Jeff Levine, AICP  
Director, Planning & Urban Development Department

April 29, 2016

Liv Chase  
Sunny Time Solar LLC  
Investment Core LLC etal  
P.O. Box 15372  
Portland, ME 04112  
Re: 49 Hancock, Falcon (Project Name),  
Investment Core LLC etal, Applicant/Owner

**STREET PARKING DIAGRAM**

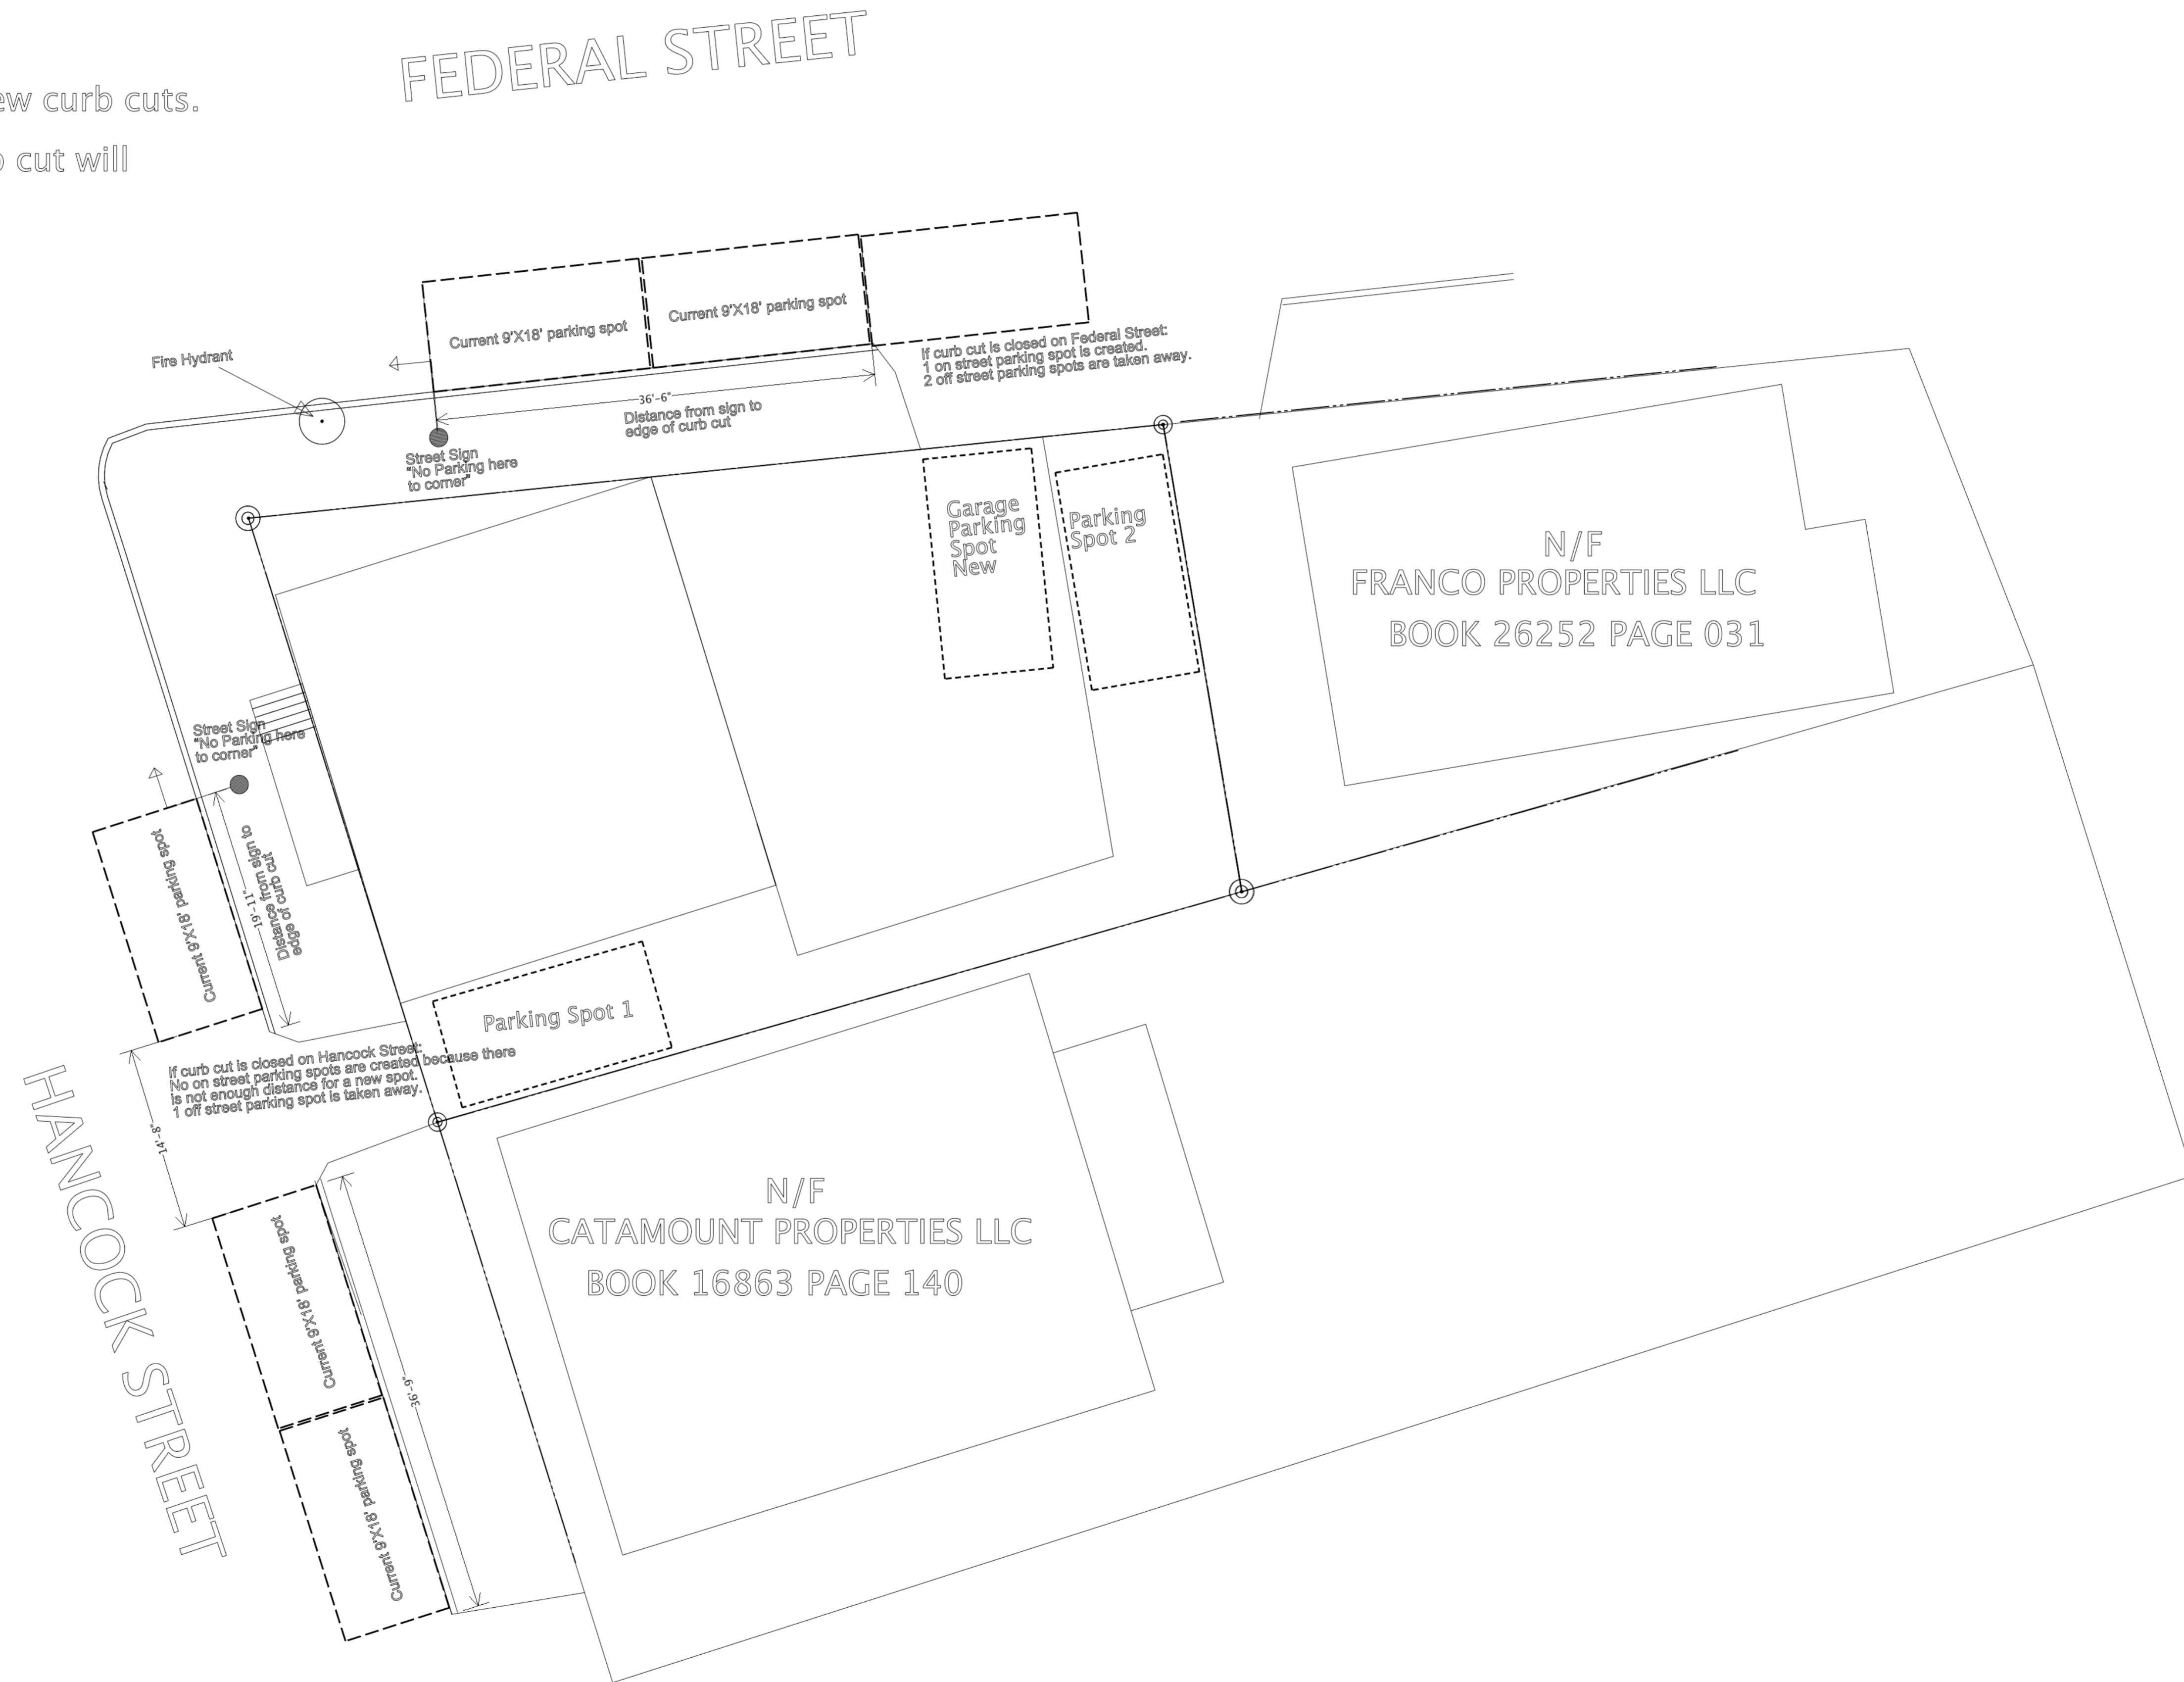
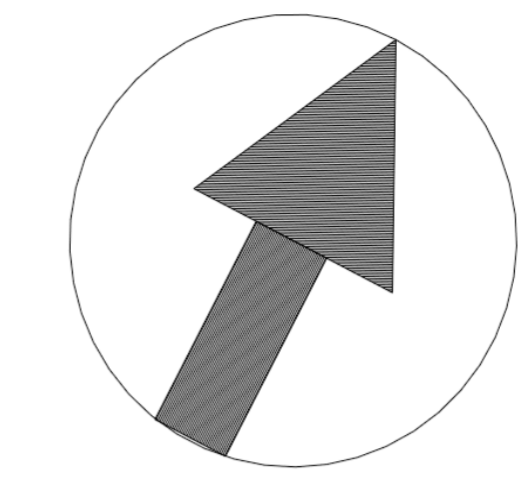
The application and the plans show the demolition of the existing rear portion of the building and a new addition that is 497 square feet larger than the existing building extension. The total building footprint of the new addition appears to be 1,178 square feet. The site plan shows two curb cuts to be retained on the site. There is no information on stormwater management for the proposal.

Thus, the proposal does not meet criteria 1, 2 and 3 for administrative authorization. The application for that level of review is therefore denied as this proposal triggers a Level II site plan review under Portland's Site Plan Ordinance.
